Application no: H14/0610/00

Description: New pre-fabricated building to
create a changing room and
functions block

Location: Pinchbeck East Primary School
Fennel Road
Pinchbeck
Spalding Lincs

Amendment: Extra sink to kitchen. Confirmation of use as meeting room,
not function room

309-01 A

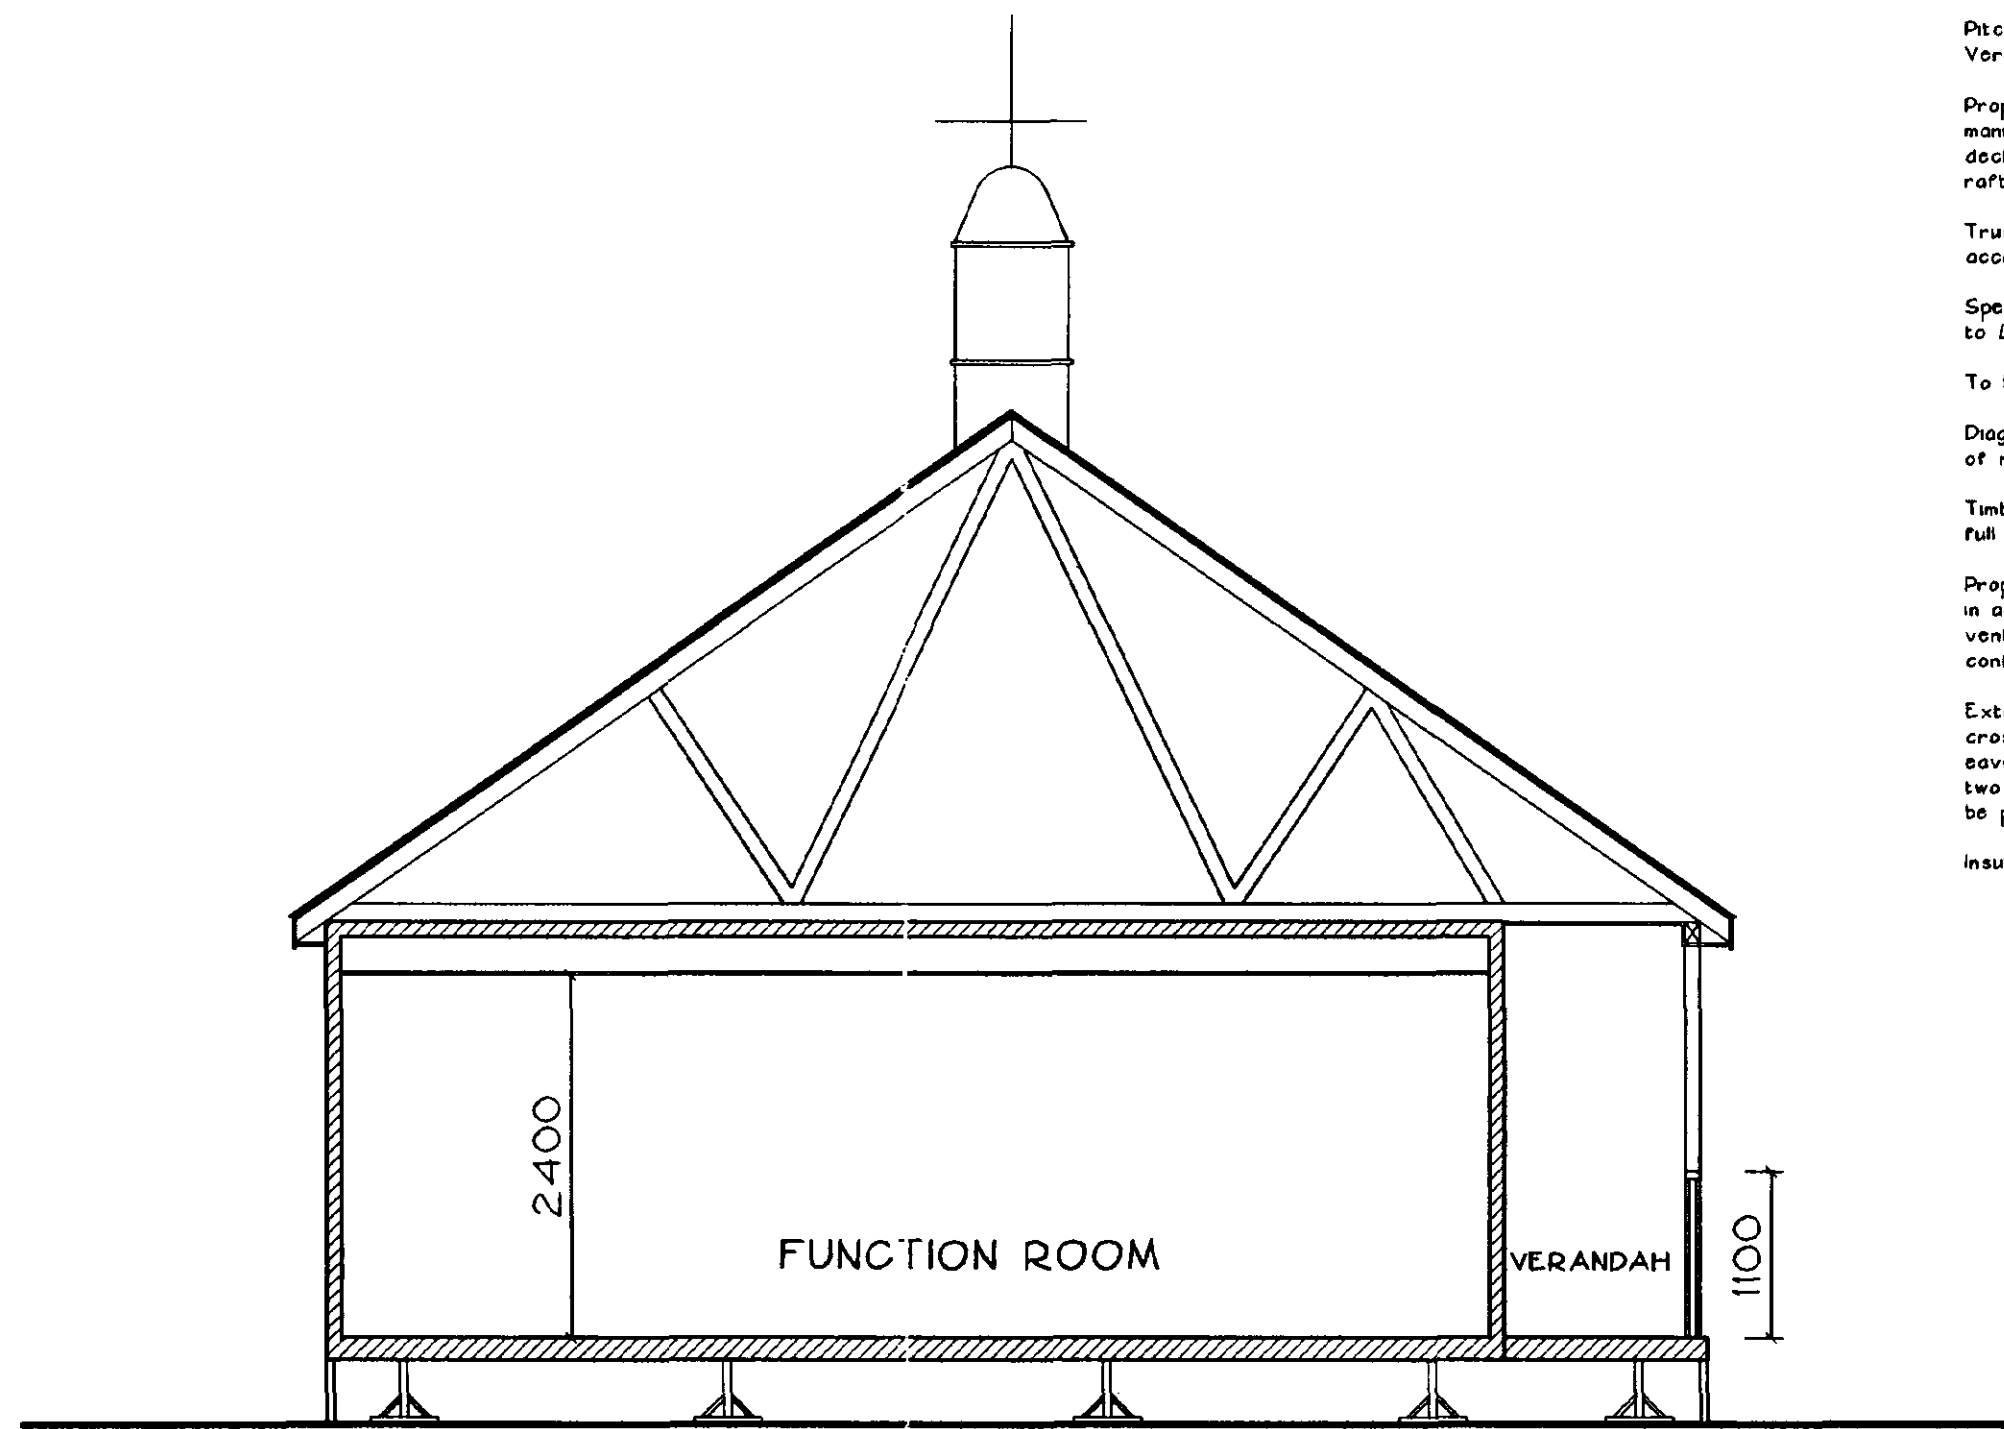
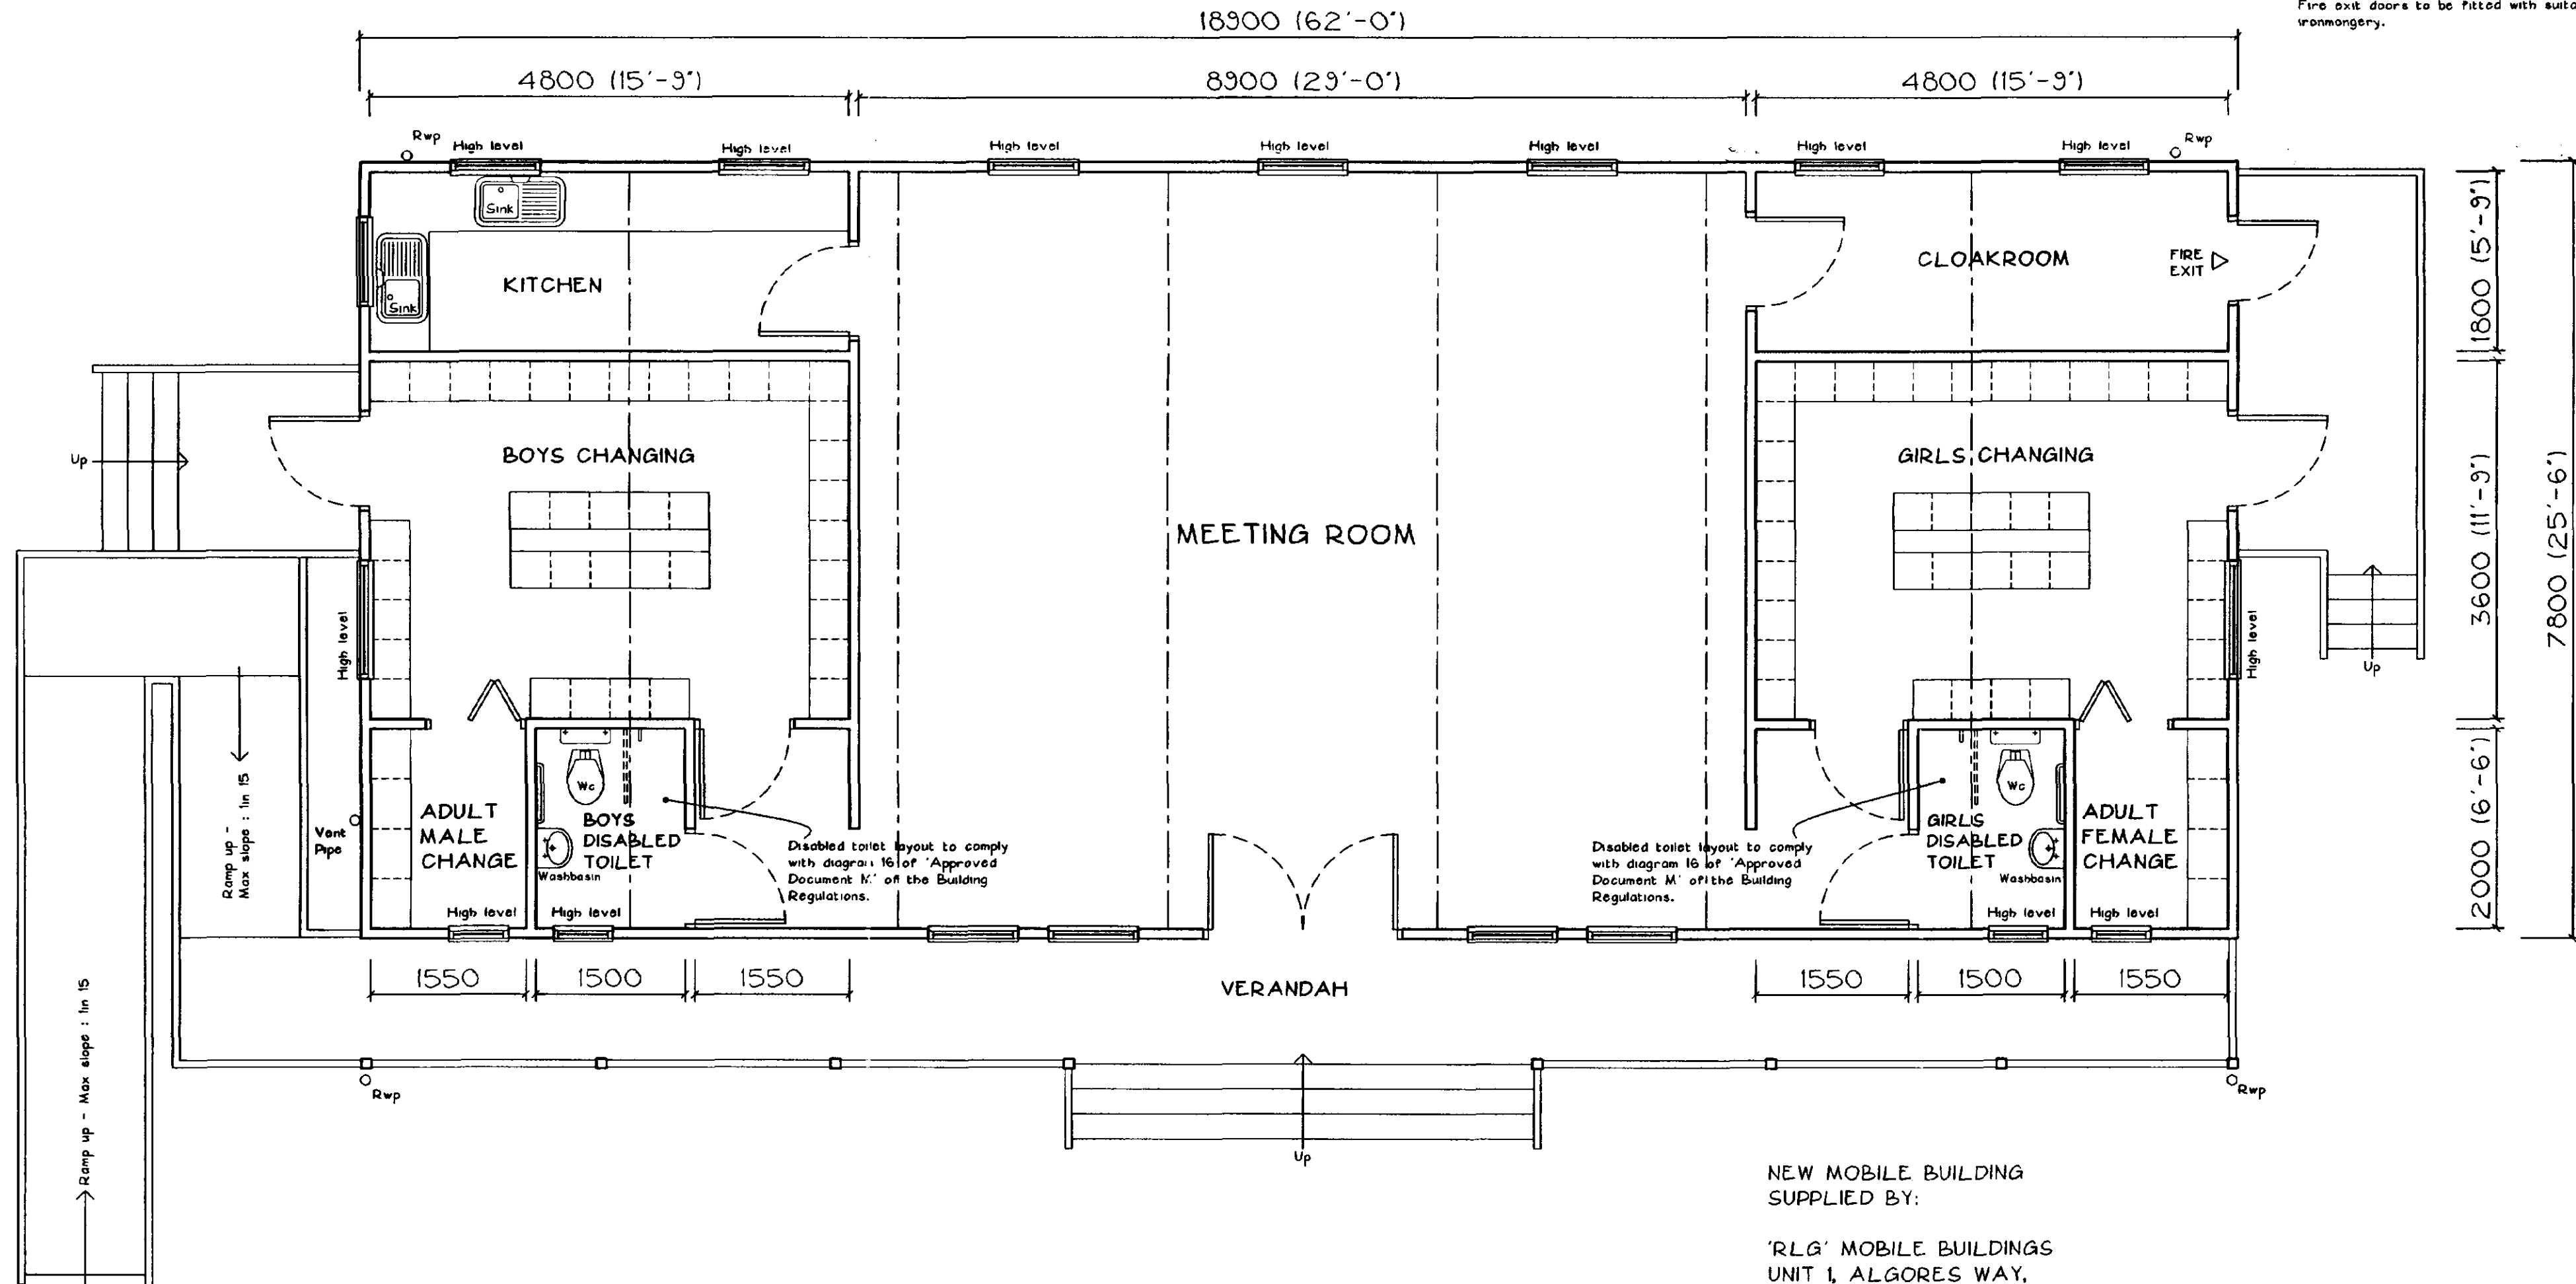
I also confirm that only small scale catering will take place and have introduced a second sink in the Kitchen area as requested by Environmental Health.

I enclose four copies of my revised drawing no 309/01A showing the Function Room amended to Meeting Room and indicating the additional sink.

On the subject of food safety it was confirmed that only small scale catering would take place. As it would be the only facilities available for use, it is recommended that a wash hand basin be installed adjacent to the single sink.
